EAST OF ENGLAND OFFICE

Our ref: PL00490033

Your ref: EN010092

PLANNING ACT 2008 : THURROCK POWER, PROPOSED THURROCK FLEXIBLE GENERATION PLANT**Historic England Deadline 5 Response (ExQ2)**

Figure 2.2 ZTV and designated heritage assets within a 5km buffer of Zone A

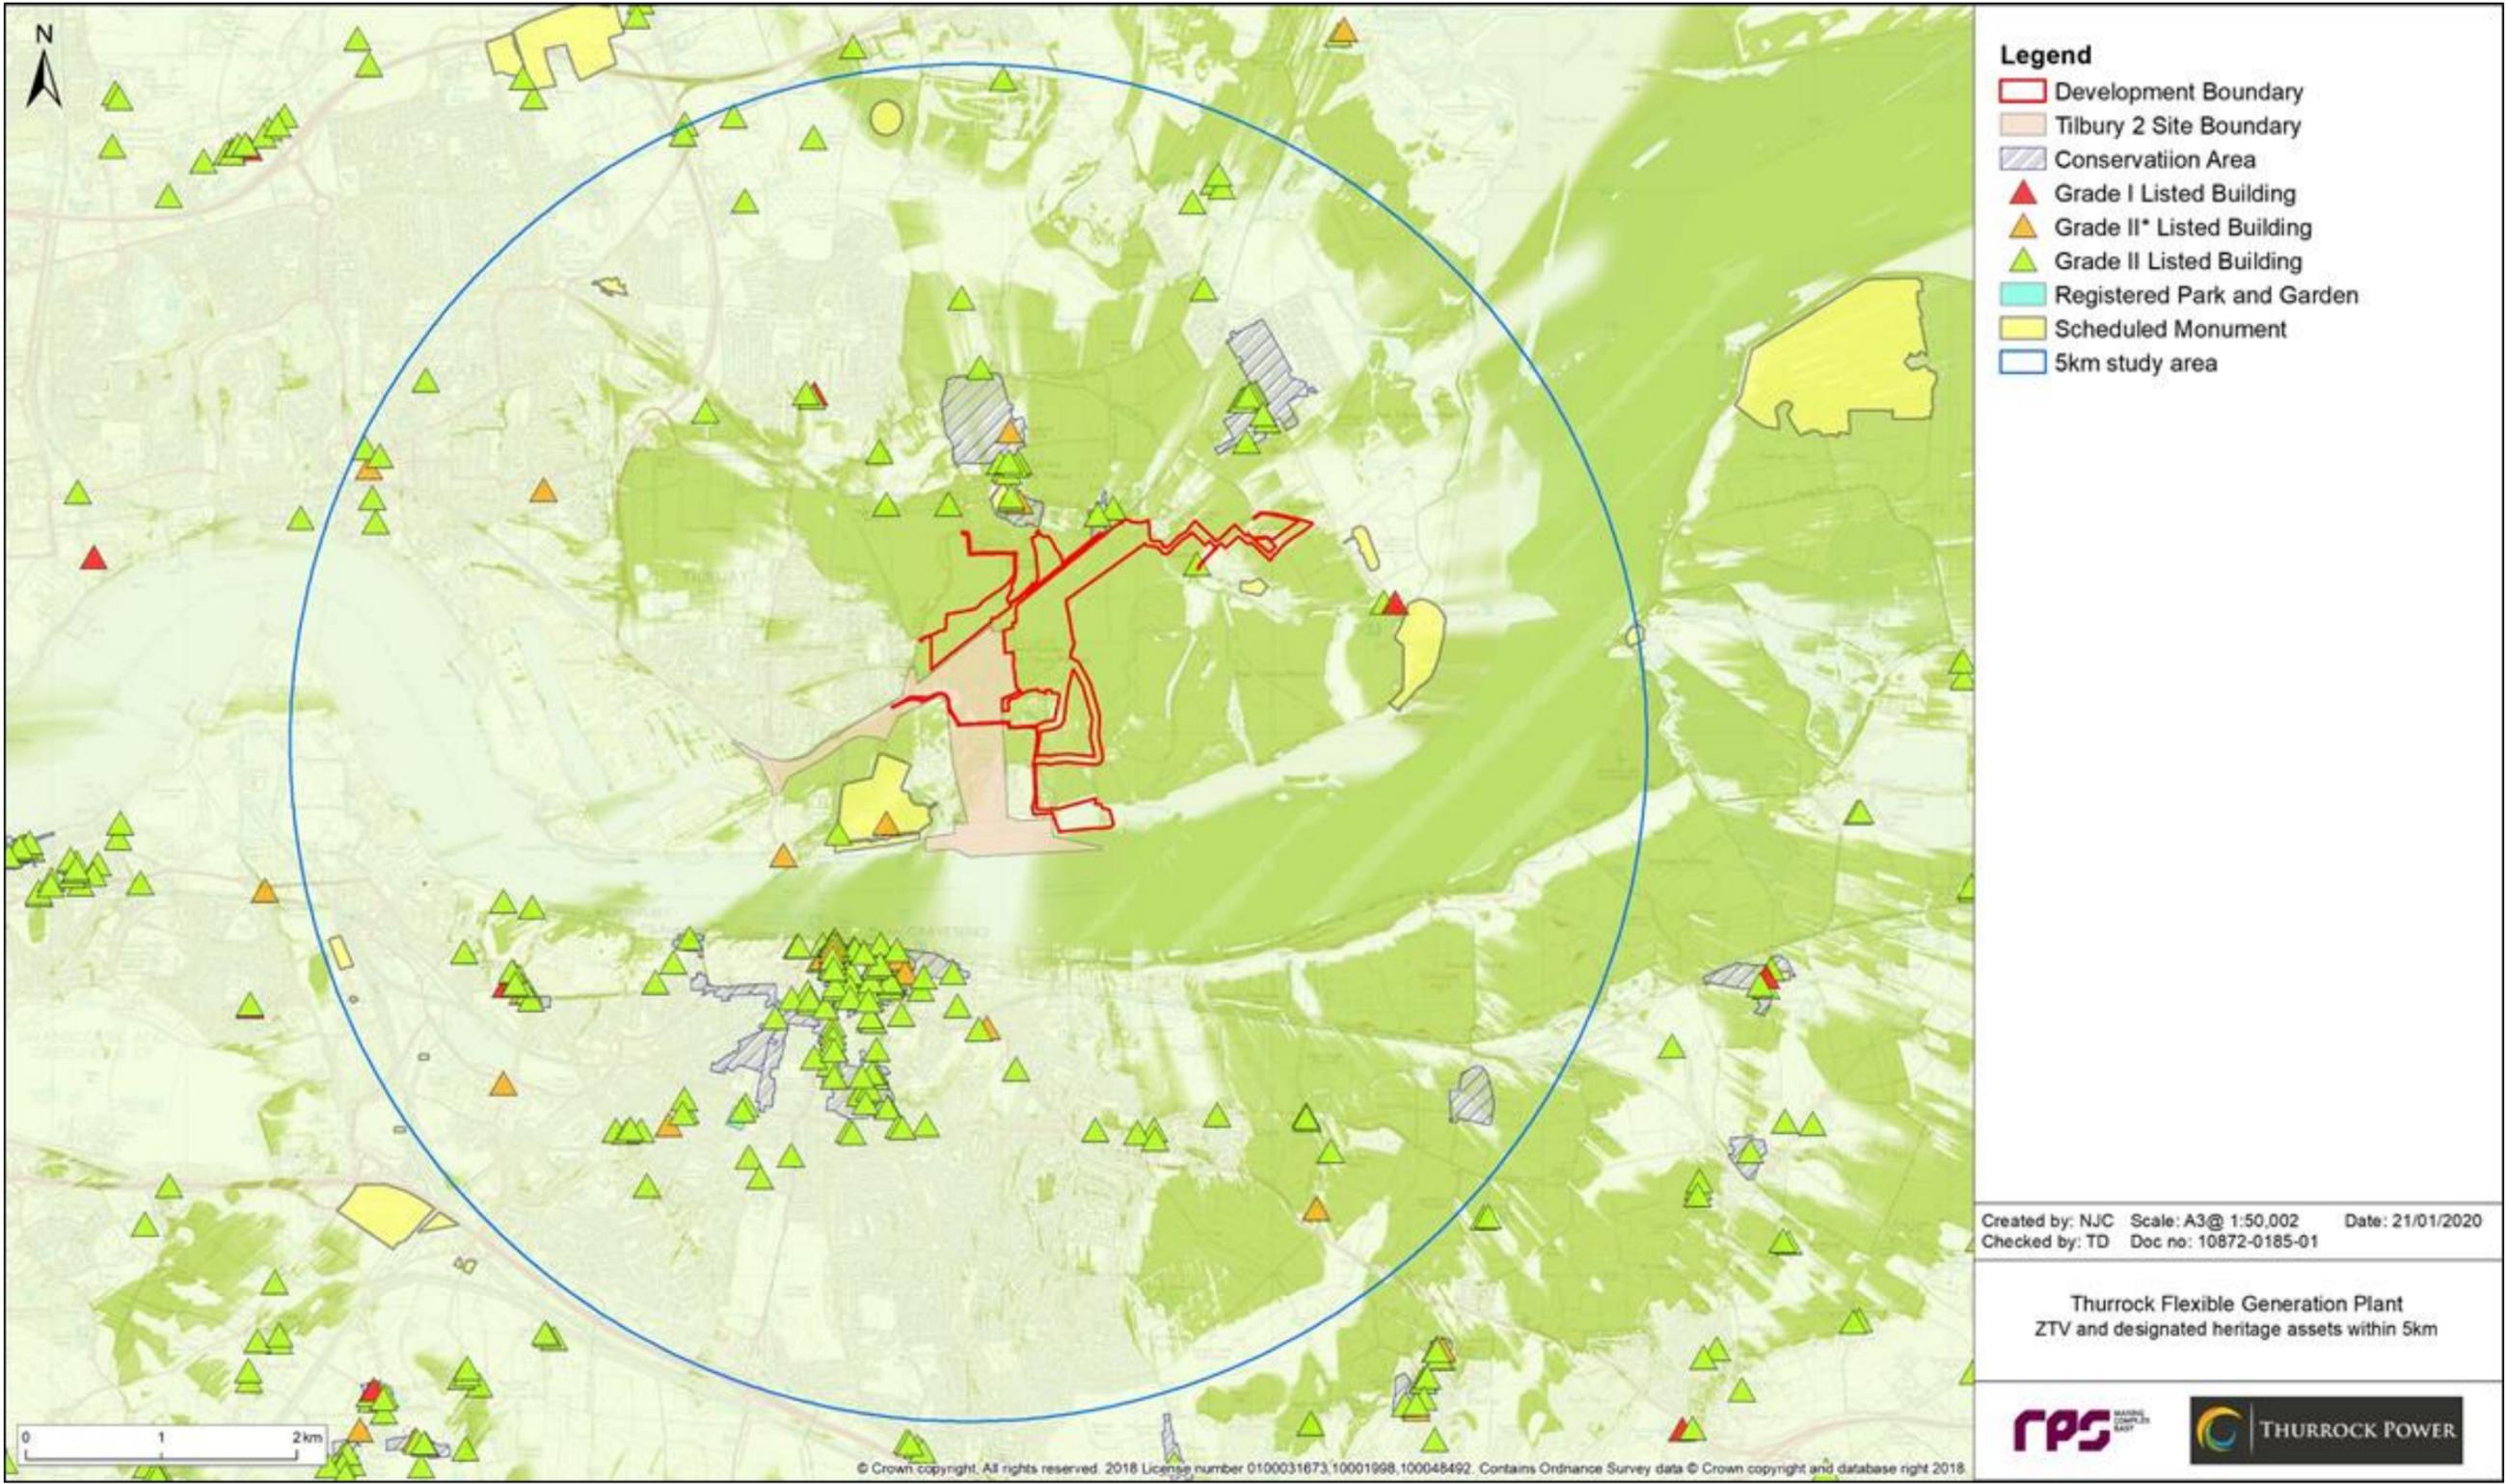
In terms of planning policy, we believe the proposed development overall would result in harm that would be less than substantial in nature but of a relatively high degree.

We believe the development would adversely affect the significance of the scheduled monument known as 'Earthworks near church, West Tilbury' and also the Grade II*

Listed Church of St James through development within their landscape setting. In our view, both the magnitude of impact and the significance of effect in both cases is moderate to high.

Both designated heritage assets are located in prominent topographic locations, on the edge of the Chadwell Escarpment, with wide views across Tilbury Marshes. As stated in our Deadline 4 response, in our opinion, the proposed development would significantly erode part of the setting, and compromise the appreciation, of both these designated heritage assets.

In terms of the scheduled monument known as Bowaters Farm Battery, there are no visualisations to support assessment – and, therefore, it is difficult to be certain about the impact. In our view, however, the harm would be of a relatively high degree, also at the upper end of less than substantial, and the significance of the effect of the scheme would probably be moderate to high – although it is difficult to be confident.

This is because the significance of this monument again draws much from its setting. Bowaters Farm Battery is located in a prominent location, with panoramic views to the west and southwest across Tilbury Marshes towards Zone A and the site of the proposed powerstation.
